Application Reference: P/107/25/DOC Site Name: Land West of Hook Lane Pagham PO21 3PB	Initial Issue Date: 31/10/25 Issue Date: 31/10/25 Reviewer Reference: ADC/EXT4
--	--

Condition 9: **Objection**

ADC Drainage Comments (P/29/25/DOC)	Designer Response	ADC Drainage Comments	Designer Response	
Date:	12/07/2024	18/07/2024	30/10/2025	12/11/2025	
Condition Number: 9 Surface Water Drainage

DESCRIPTION
ATTENUATION TANK 1
using GRAF ECOBLOC FLEX

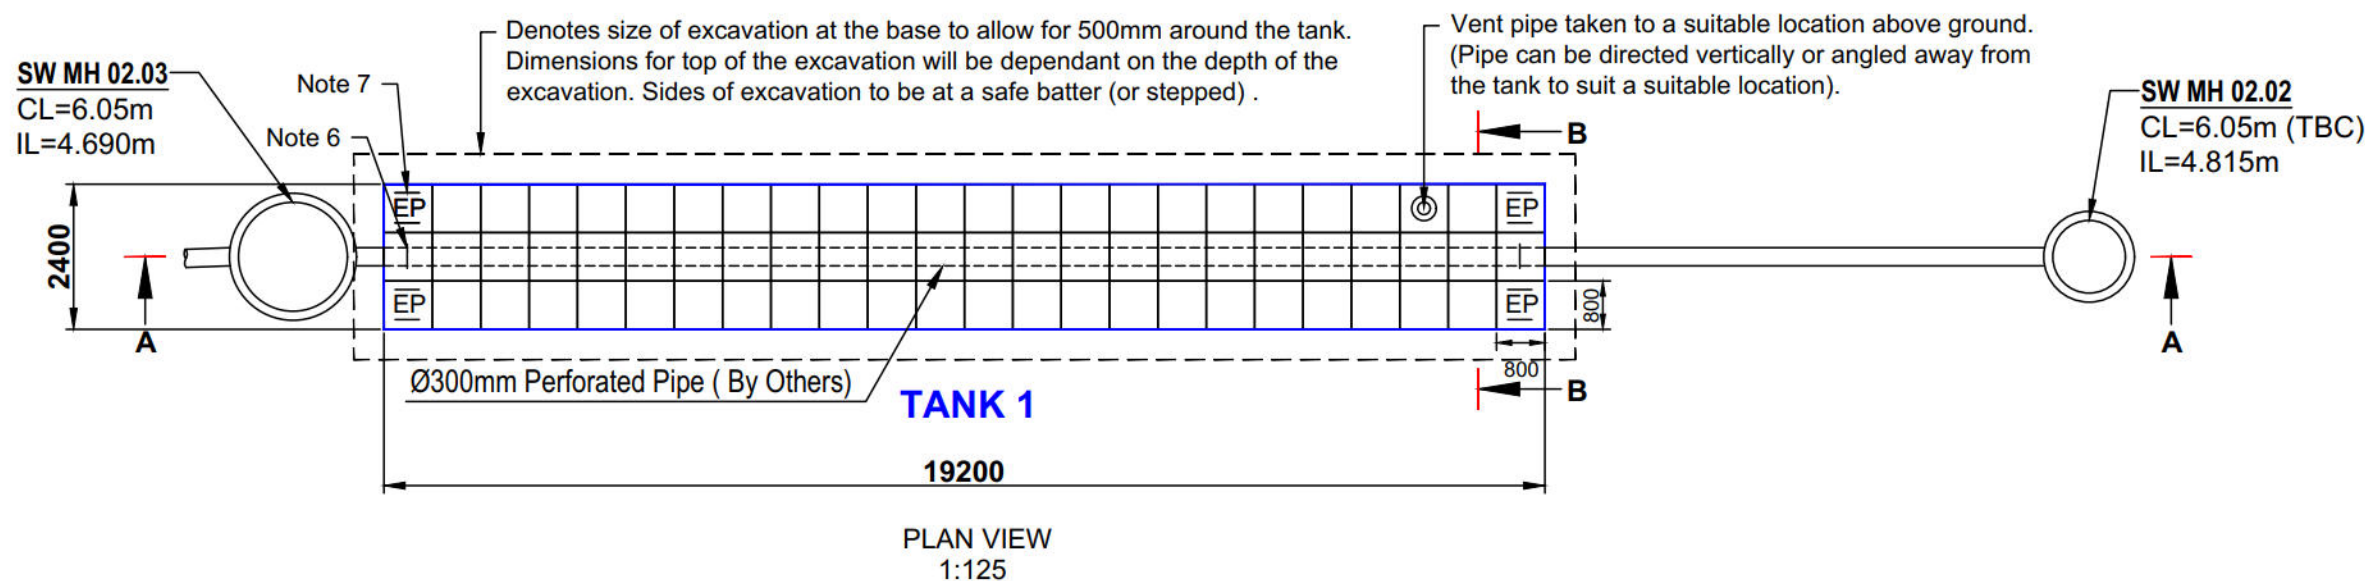
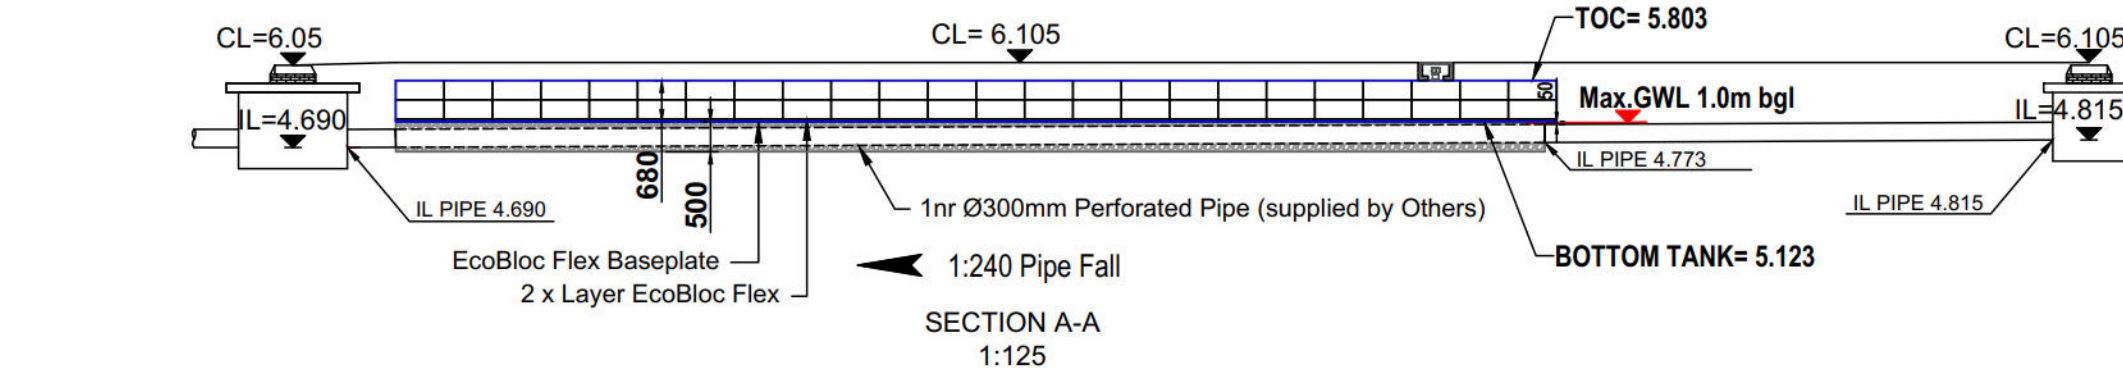
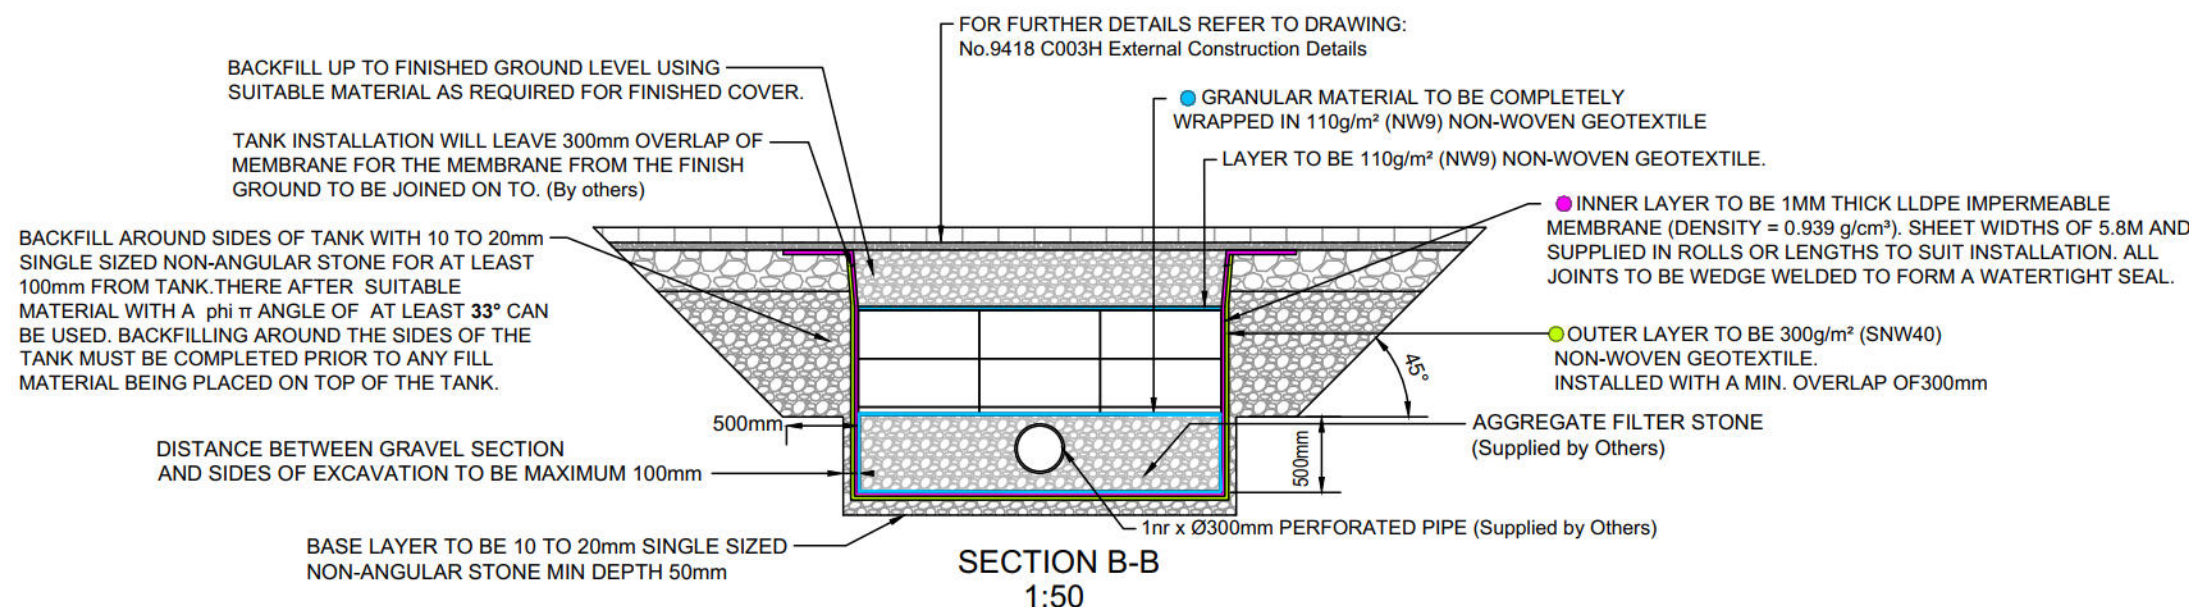
d) Vent pipes are shown on the top of the tank “by others” connecting to the upstream and downstream chambers, no details are provided showing how these chambers are vented e) The tank detail suggest that pipes run through it at base level, this is not shown on the plan f) The tank detail refers to Ecobloc and Stormcell, the plan refers to Aco Stormbrix. g) The tank detail does not state which specific product in the range it to be used. eg. There are 3 types of Stormbrixx h) The tank detail specifies a plan size that is not consistent with the drainage plan i) The tank detail makes reference to “final detailed design by Ecobloc. Provide the final design j) The permeable paving detail shows a 150mm perforated pipe, the	D. Updated Drawings & Calculations.. E. Updated Drawings & Calculations. F. Rev. C calculations. GRAF ECO block MAXX clearly shown. Updated Drawings & Calculations. G. Updated Drawings & Calculations. H. Rev. C Calculations. Updated Drawings & Calculations. I. We have removed this note. This should be forwarded later after PLANNING. J. No impact. Updated Drawings & Calculations.	perforated distribution pipe B. Item now closed C. Item now closed D. Item now closed E. As per comment to A F. Item now closed G. Item now closed H. Item now closed I. The detailed design of these tanks are required to support this condition J. Item now closed K. Item now closed L. Item now closed M. item now closed N. Item now closed O. Item now closed P. Item now closed	See Appendix H for detailed Graf Drawings.

TYPICAL INSPECTION CHAMBER DETAIL

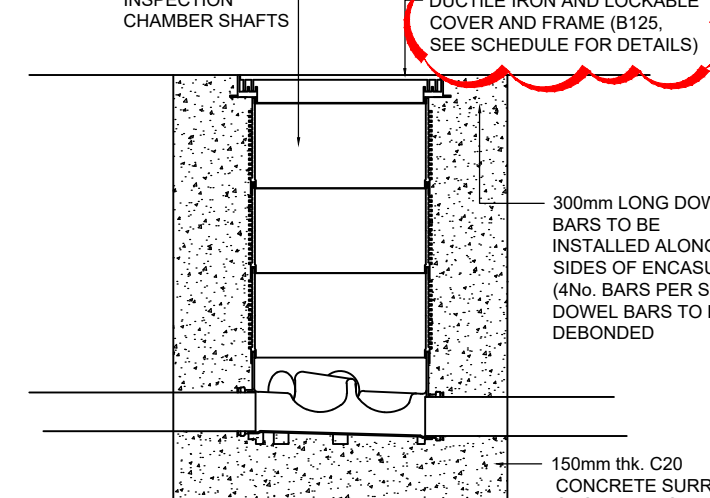
p) The Typical inspection chamber detail appears to show a light duty cover which contradicts the manhole schedule Provide revised drawings and calculations that are coordinated and consistent	P. Inspection chamber covers are not shown on the Manhole Schedules. Updated Drawings & Calculations.

TYPICAL SECTION ALONG ATTENUATION SYSTEM (REFER TO DRAWING C016)

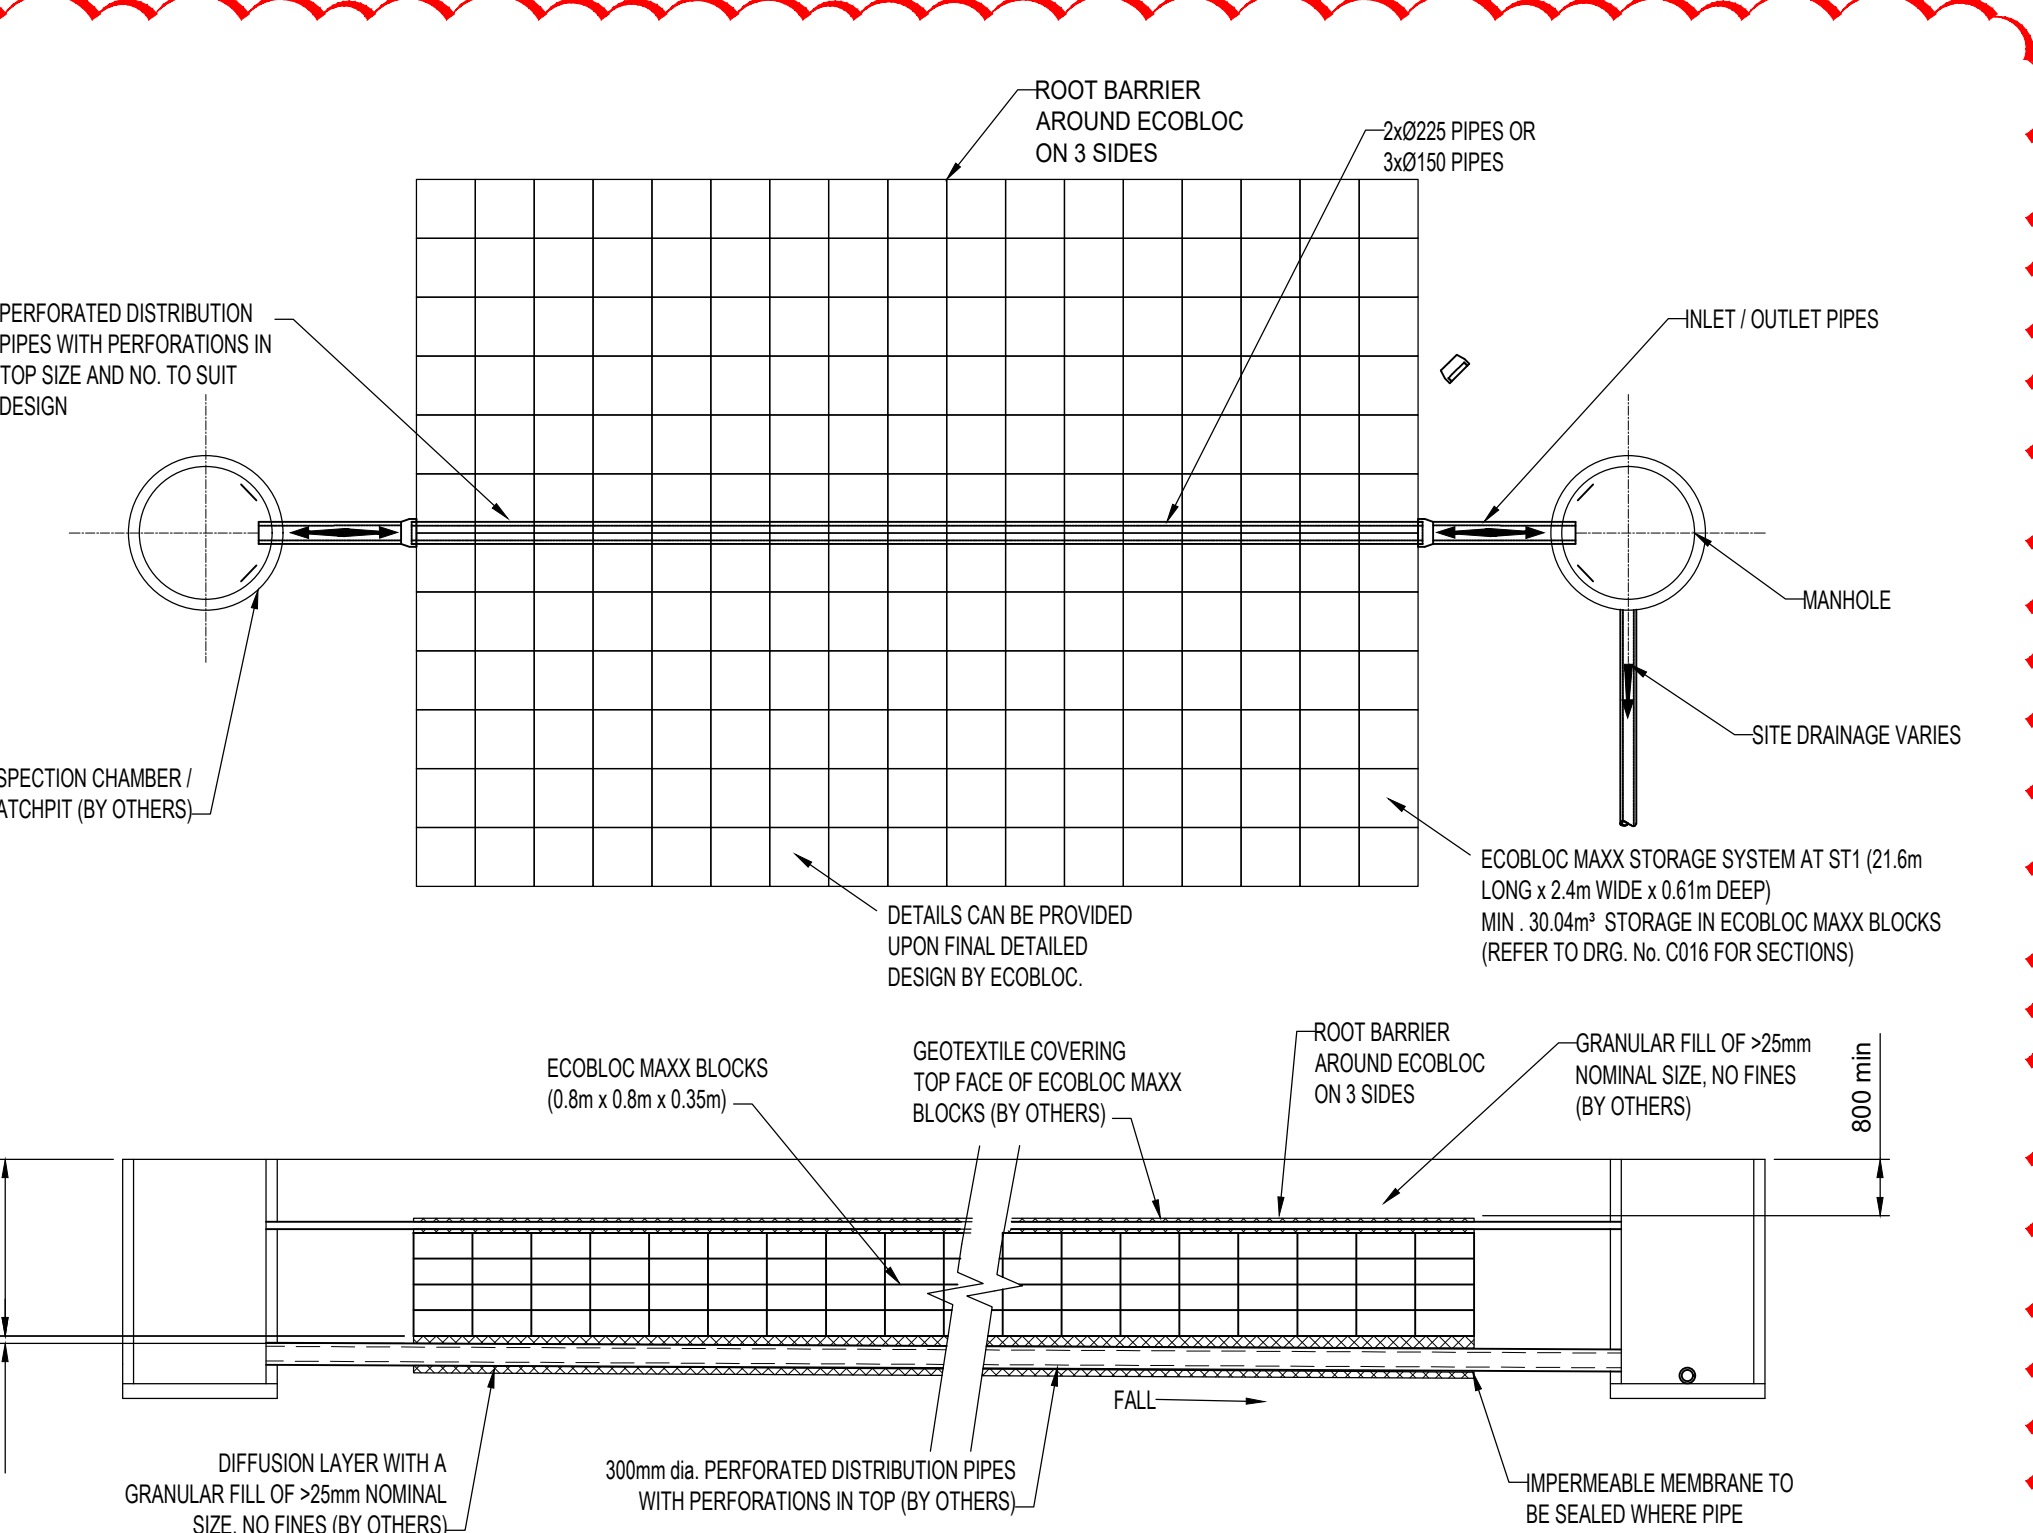
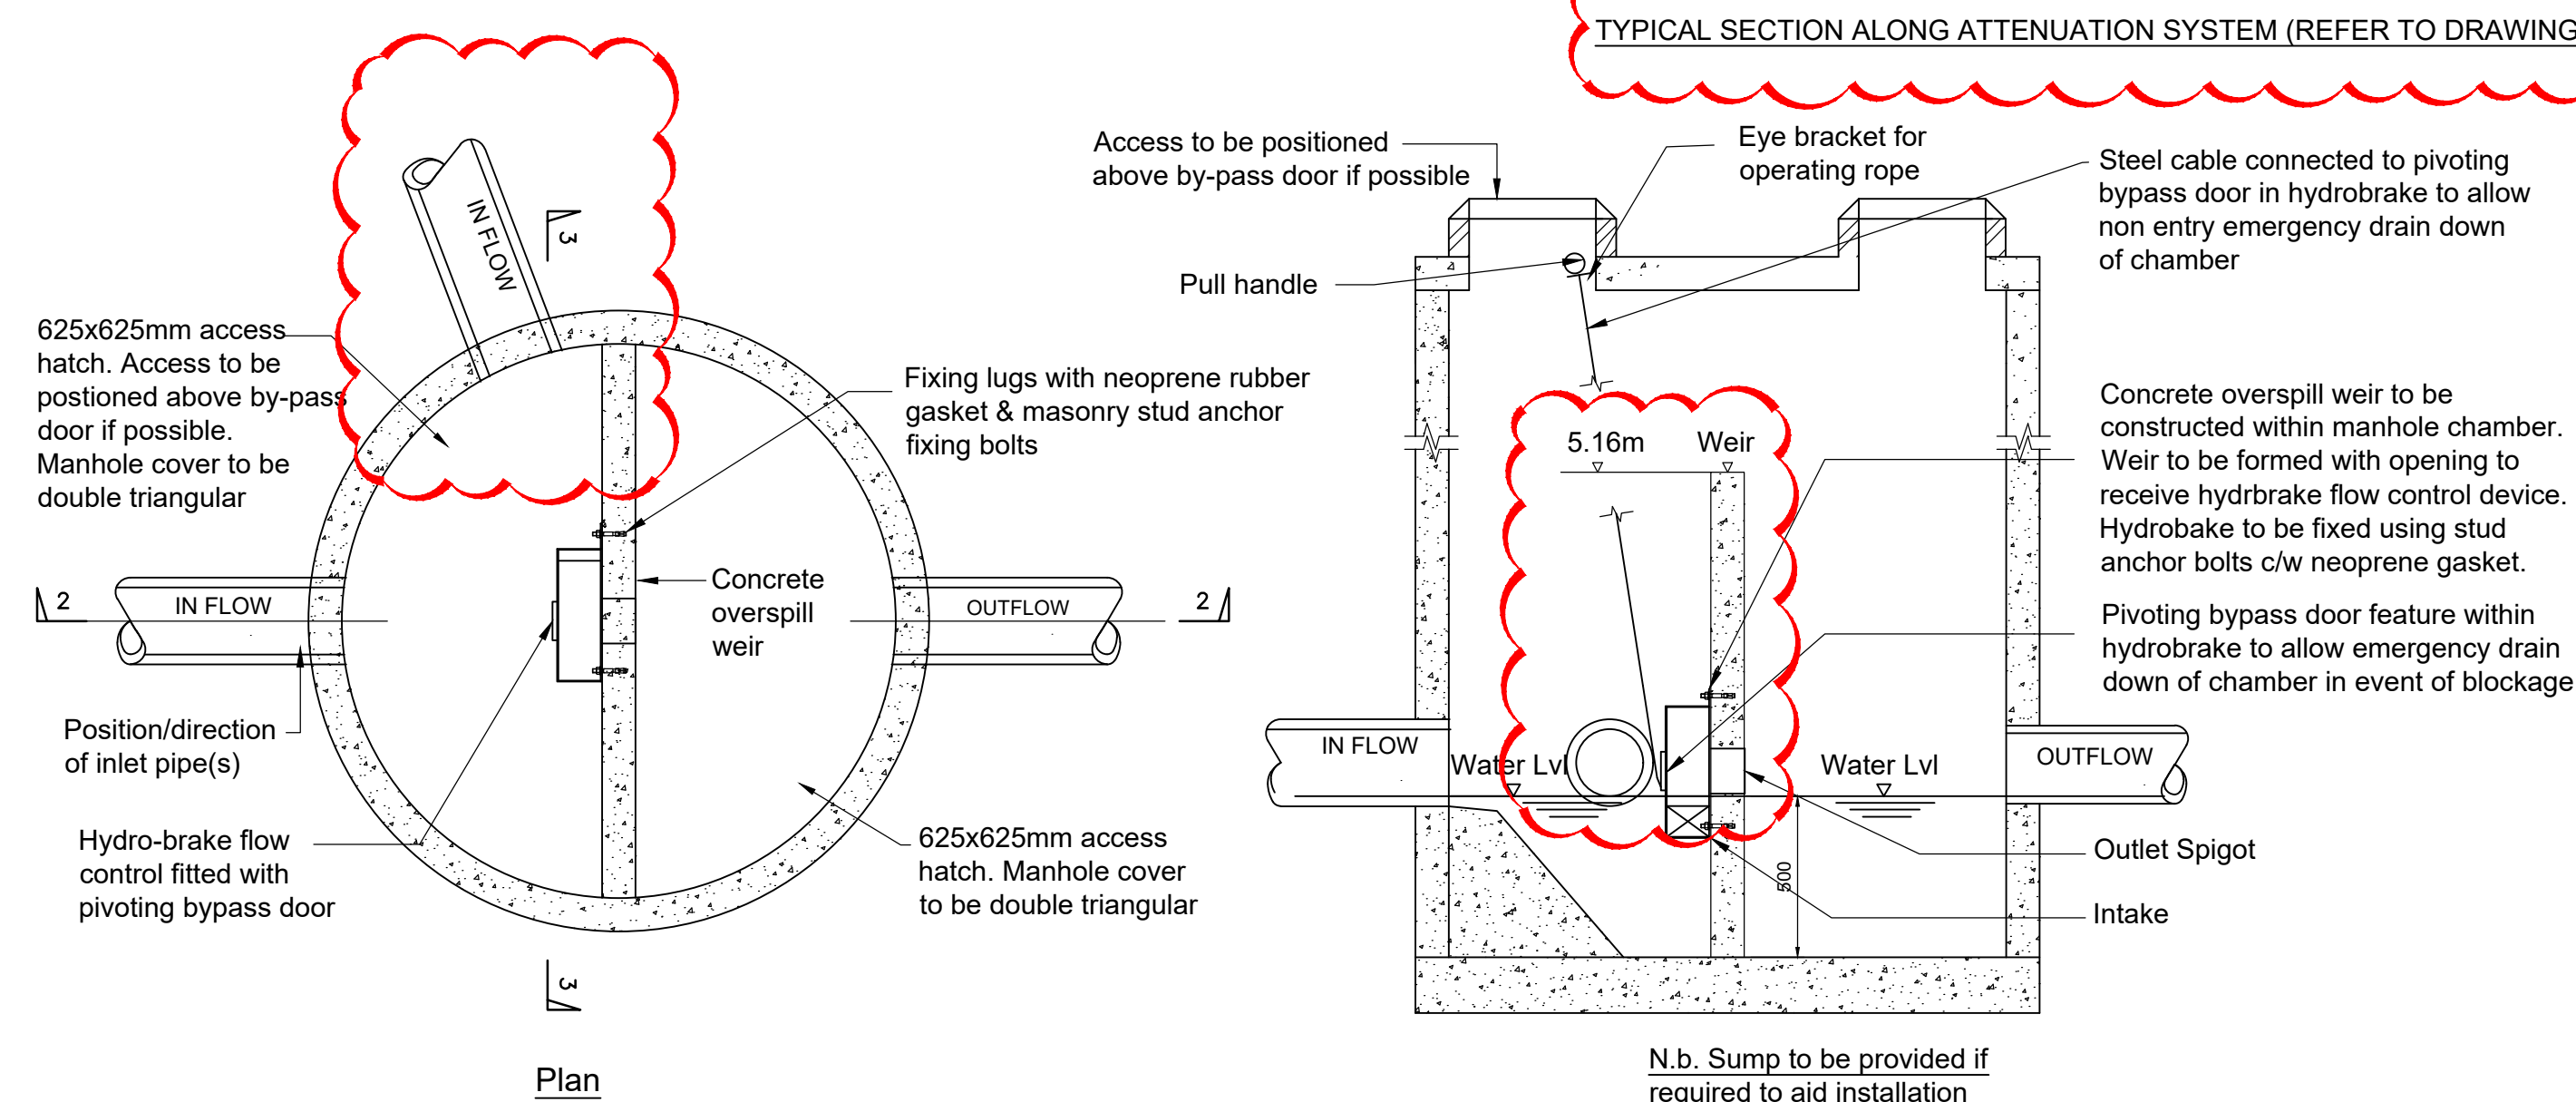
6)	The drainage construction details are not consistent with the others plans and the calculations. a) The tank detail shows a manifold arrangement for the tank connections, the plan shows a single pipe b) The tank detail shows catchpits upstream and downstream of the tanks, they are not shown on the plan or manhole schedule c) The volume stated for tank ST2 is not consistent with the plan	A These details were provided in Rev C. calculations. Updated Drawings & Calculations. B. These were provided in Rev. C calculations. Updated Drawings & Calculations. C. This was provided in Rev. C calculations. Updated Drawings & Calculations.	A. The tank detail on drawing 9418-C003-H still indicates conflicting information. The plan section indicates 2x 225mmdia. Or 3x150mm dia pipes whilst the section indicates a 300mm	We have provided revised drawings in Appendix F.

Dual entry weir wall control manhole detail as SW MH 02.04 Not to Scale

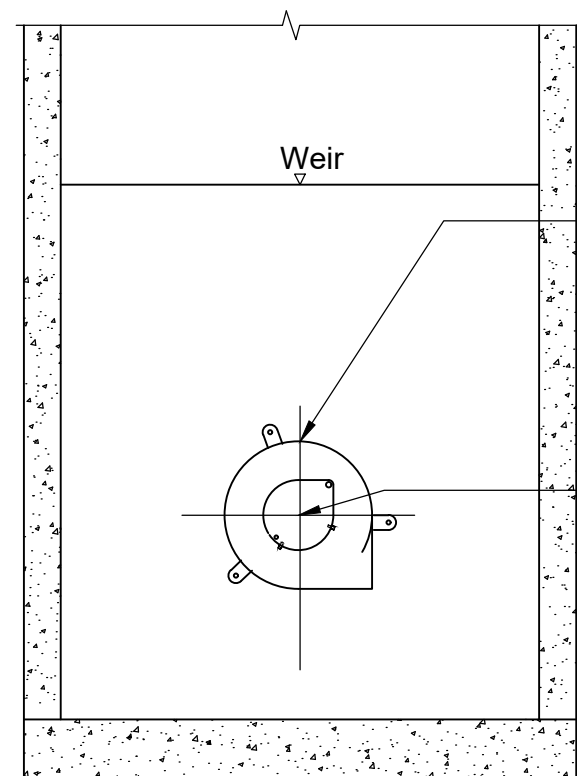
calculations and plan show a 225mm perforated pipe k) The flow control chamber detail does not appear to reflect what is shown on the plan l) Provide details of how the flow control device will be protected from blockage given that its pass through is less than the recommended 75mm m) The typical manhole detail states a range of diameters that are dependant on depth and contradict the manhole schedule n) Demonstrate that sufficient working space will be available under the cover slab in the 1200mm dia manholes (usually 900mm is required from top of benching to underside of cover slab) o) The typical manhole detail shows a grade D400 cover which contradicts the manhole schedule	K. Rev. C Calculations - Updated Drawings & Calculations. L. As shown on details – steel cable connected to pivoting bypass door for blockages as shown on C003 drawing. M. These are standard details. Updated Drawings & Calculations. N. Manhole Details show rungs at 300mm centres. There is greater than 1m height (5no). The note also indicates step irons not required where O. D400 covers are only shown on Manholes in Road/Parking areas. See Drainage Plan for details. Updated Drawings & Calculations.
